Please ask for: Nicola Moore
Email: nicola.moore@arun.gov.uk
Telephone: Ext 37944
Our Ref: AW/287/20/T
Your Ref:
Date: 22nd October 2020

Application for Works to Trees(s) subject to a Tree Preservation Order(TPO)

Development: Fell 1 No. Rowan tree
Location: Ashlyn 19 Craigweil Manor Aldwick PO21 4DJ

PLAN

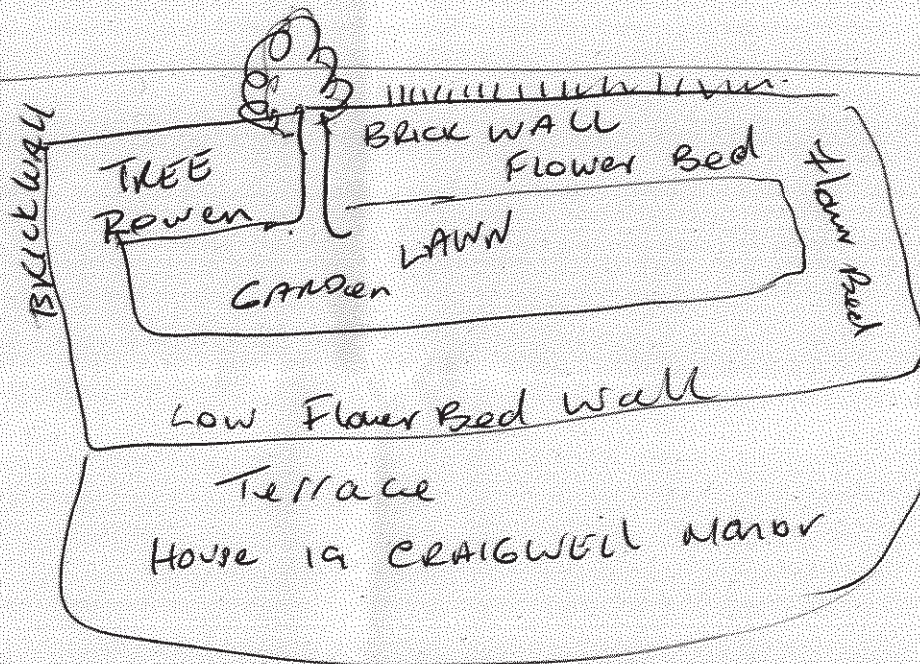
The location of the tree to be felled is not clear on the plan submitted. Please submit a sketch plan clearly showing the location of the tree. The plan should show road names and adjoining properties. A North point is helpful.
